7 June 2010

**ROYAL REHABILITATION CENTRE SYDNEY SITE, 600 VICTORIA ROAD, RYDE
AMENDED SECTION 75W MODIFICATION OF THE MINISTER'S APPROVAL FOR
TORRENS TITLE SUBDIVISION (MAJOR PROJECT NO. 07_0100)**

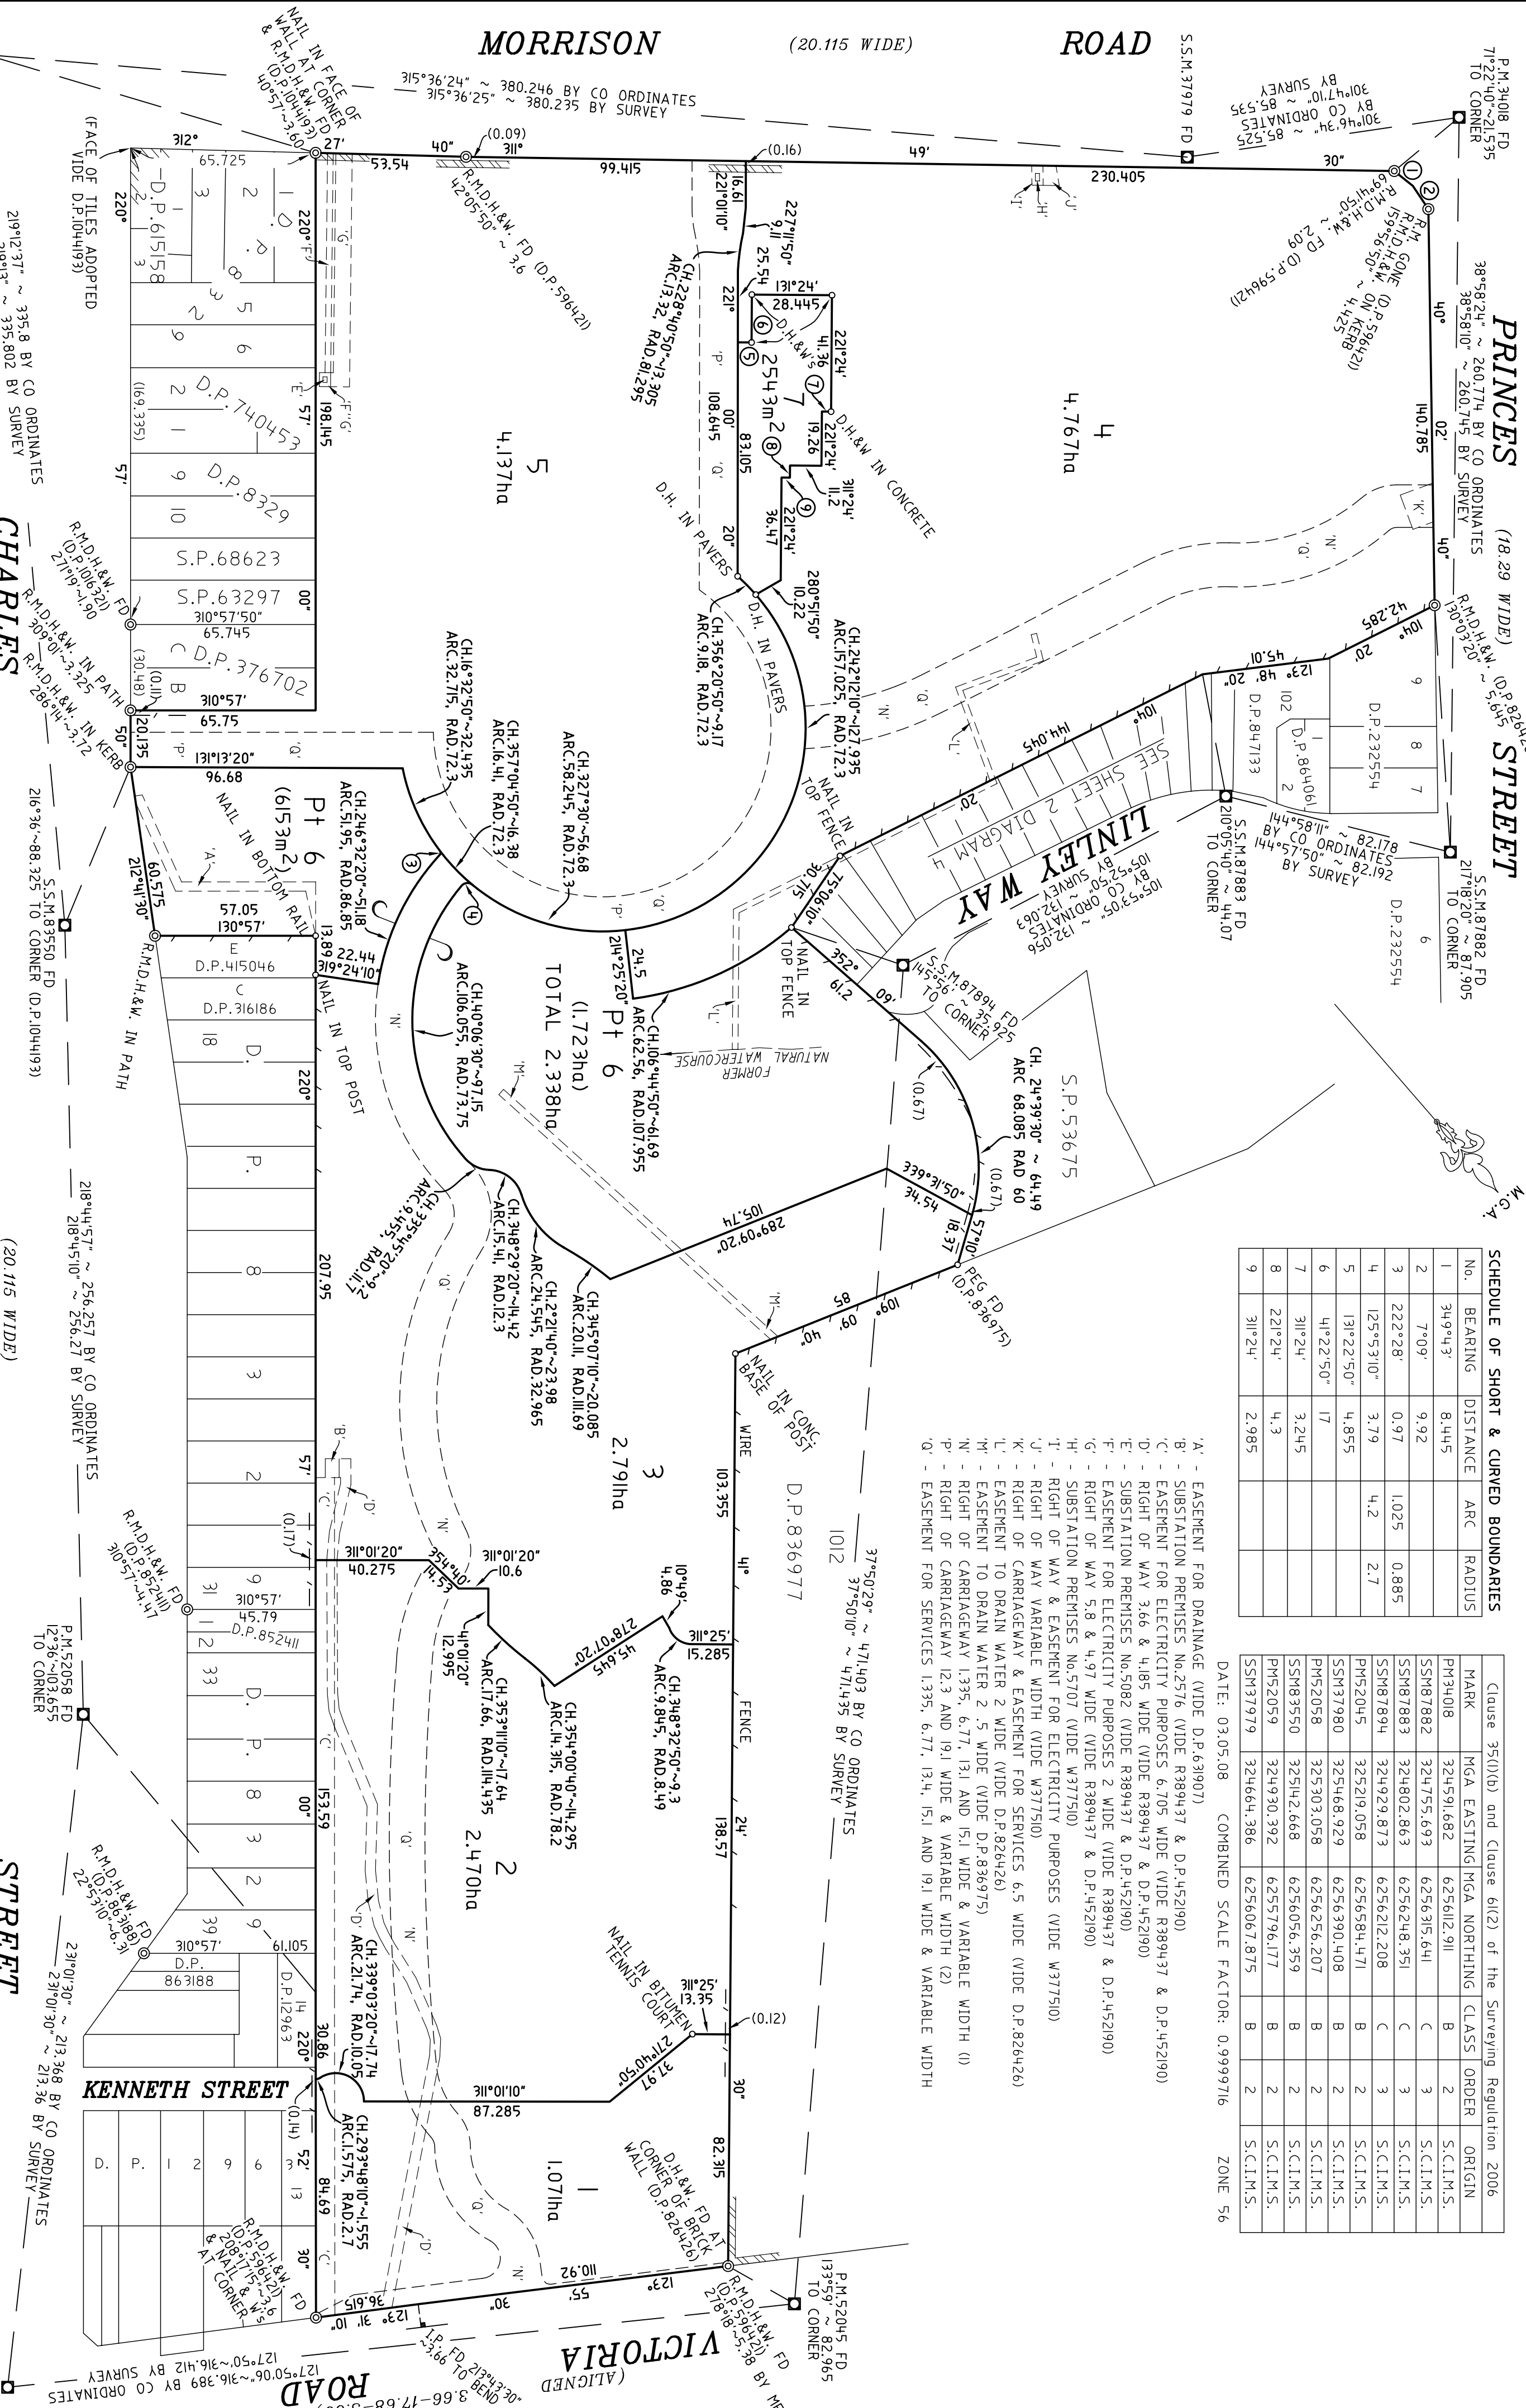
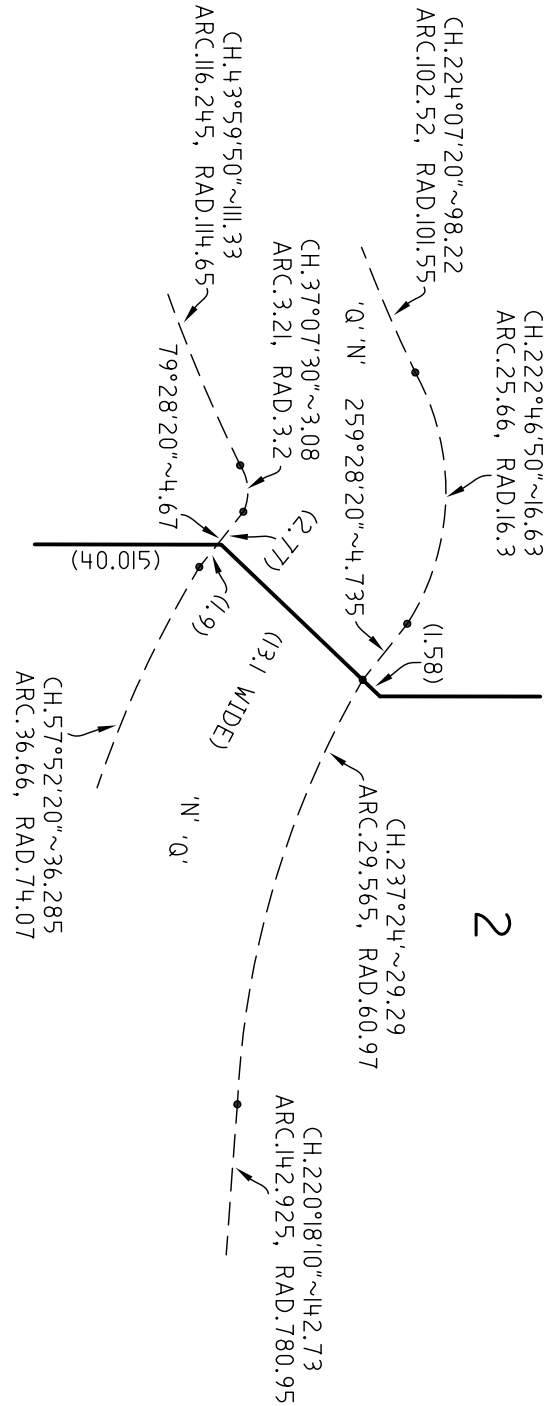
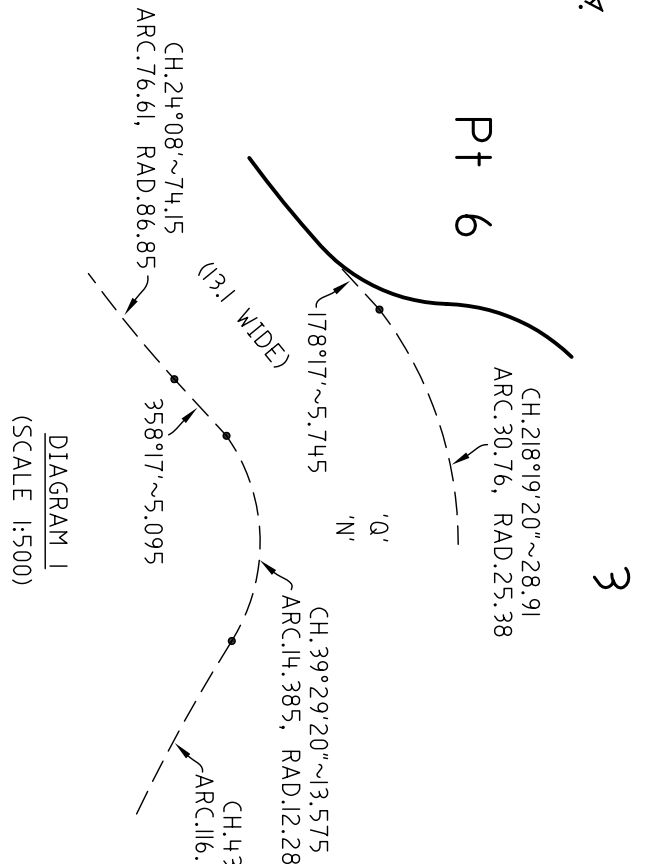
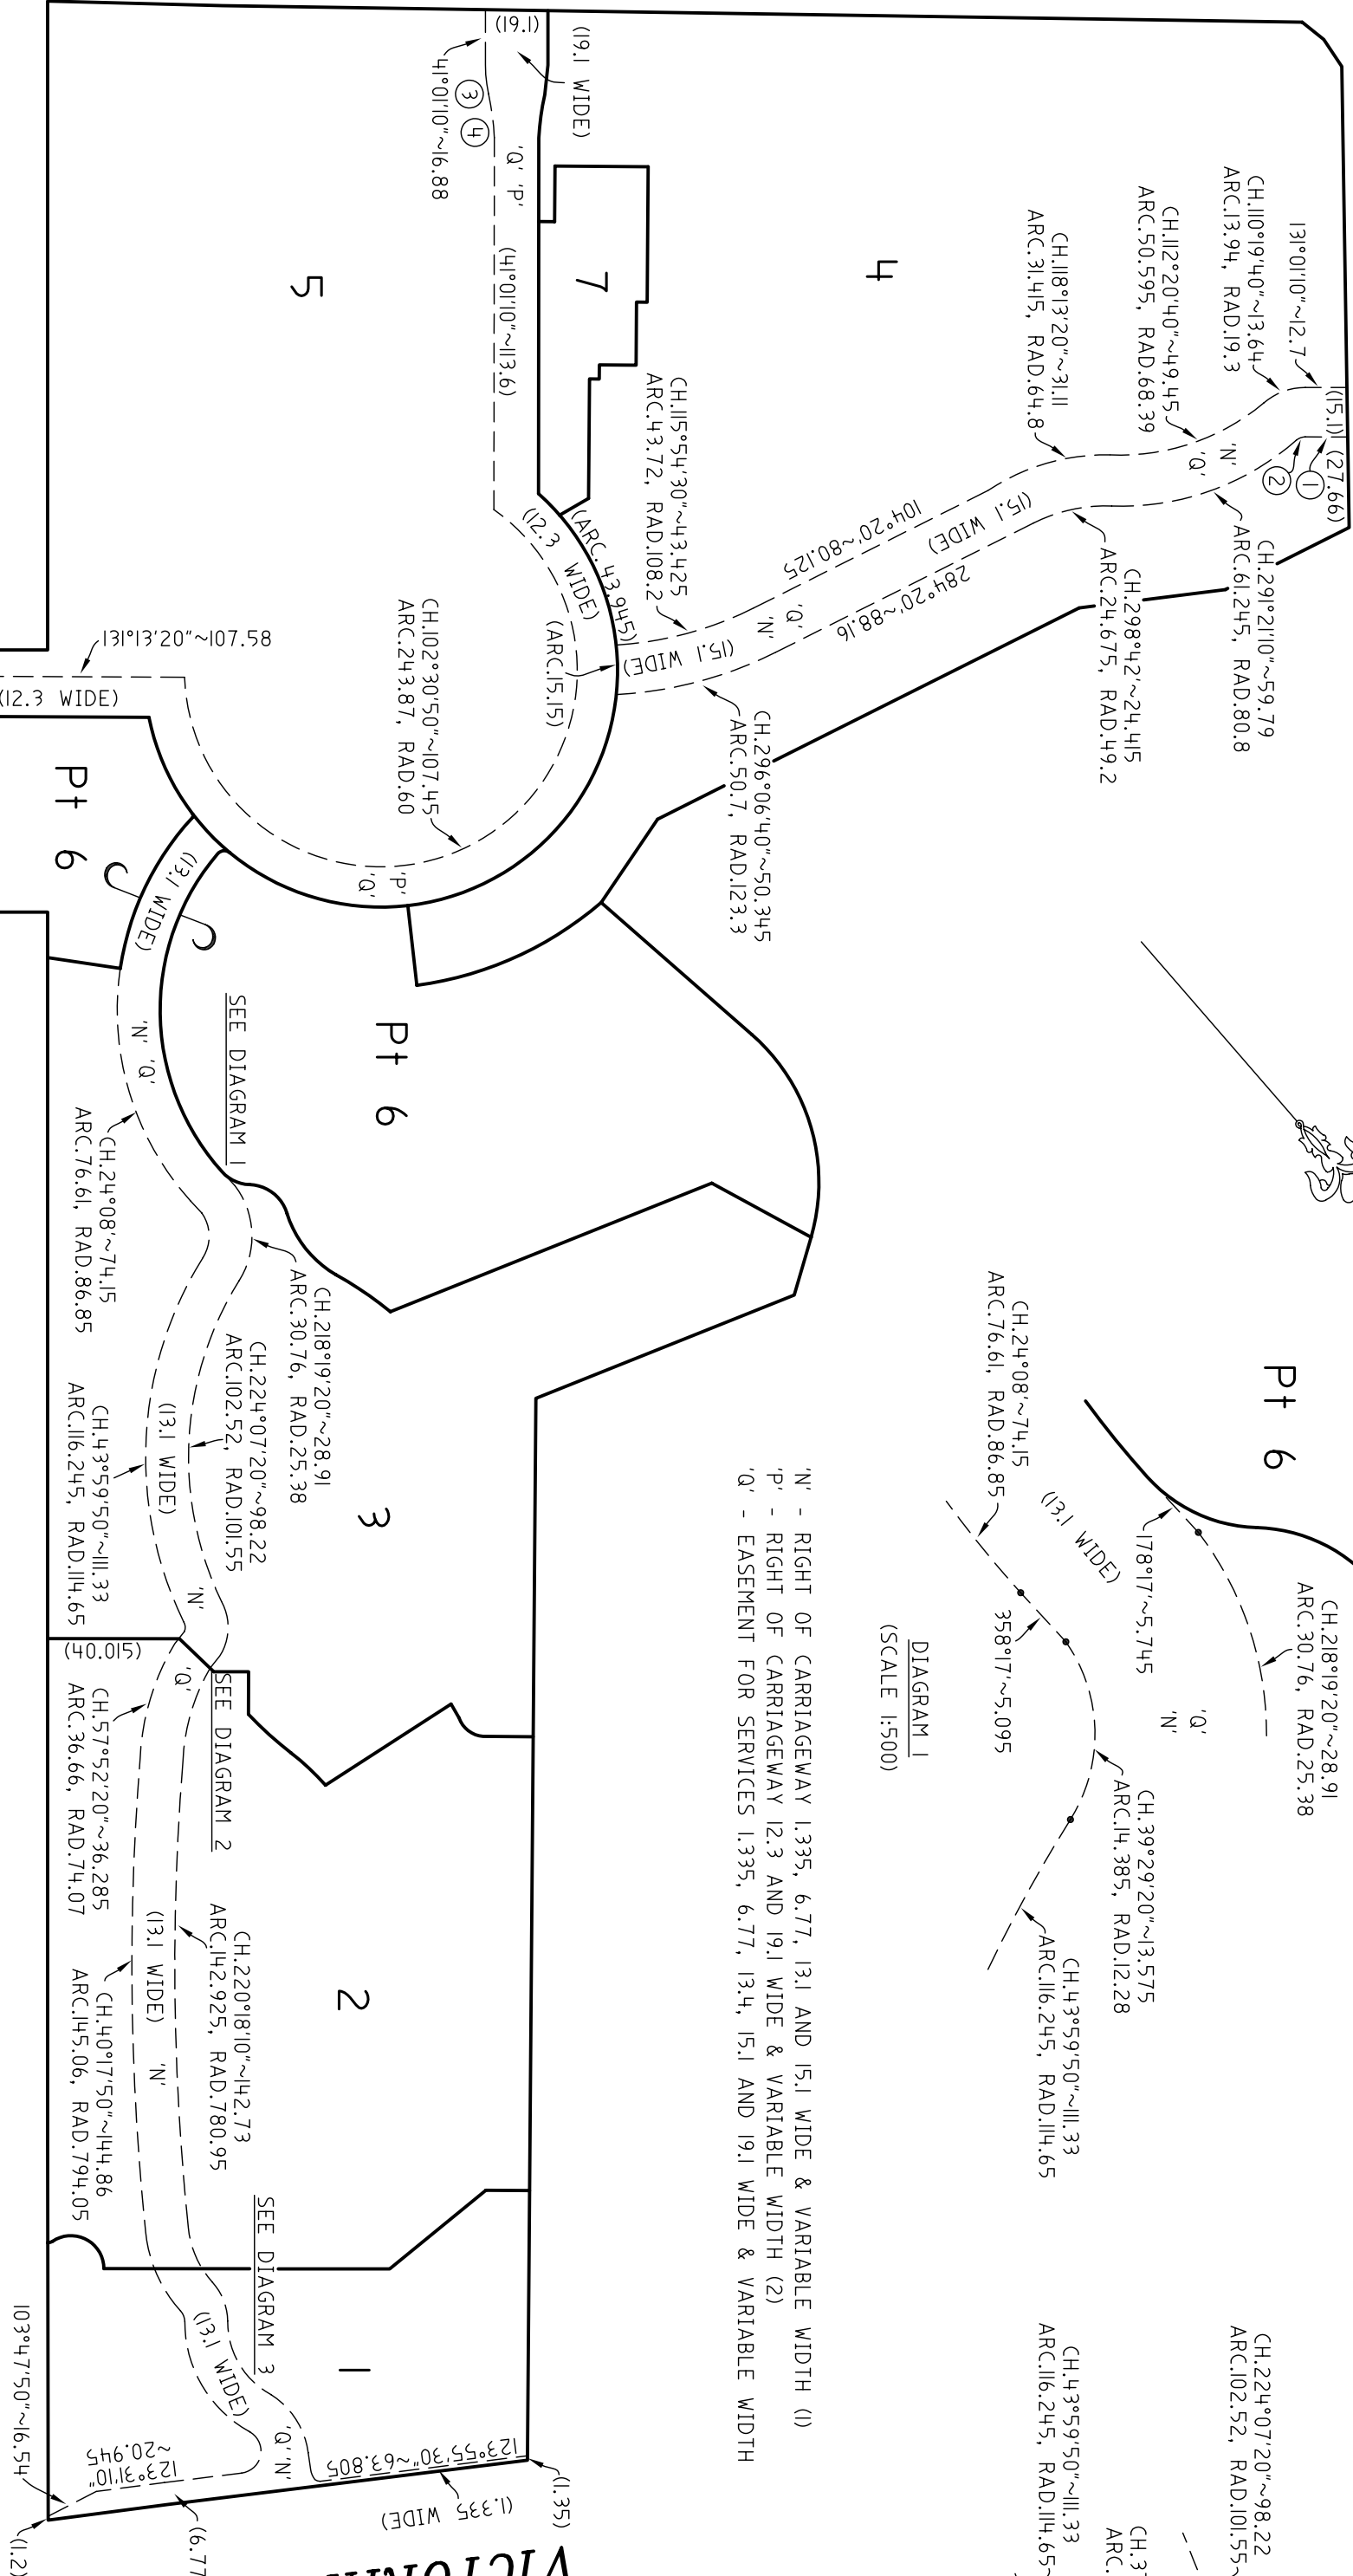
1. At the north-western narrow section of approved Lot 3 and approved Pt Lot 6 (respectively renamed Lot 8 and Lot 9 in the Modified Subdivision Plan in accordance with Land Title Office requirements for consecutive numbering of lots). The discrepancies between the two plans arise from the fact that the Approved Subdivision Plan shows an angled boundary at the north-western end of what was previously Lot 3, at the point where it adjoins what was previously Pt Lot 6. In contrast, the Zoning Map shows a sharp right angled corner at this point. The width of the north-western handle to previous Lot 3 has also be narrowed to match the Zoning Map.

2. The boundary between the previous Lot 3 and Pt Lot 6 on the eastern side of the parkland area. The boundary on the Approved Subdivision Plan shows a sharp change in direction, whereas the boundary on the Zoning Map curves around the south eastern side of the parkland area.

The Modified Subdivision Plan (**Attachment 3**) seeks to amend the Approved Subdivision Plan in respect of both of these discrepancies, in order to ensure that it is more in line with

the Zoning Map and Concept Plan Approval. As illustrated by the overlay of the Zoning Map and Modified Subdivision Plan (**Attachment 4**), the two plans are now aligned.
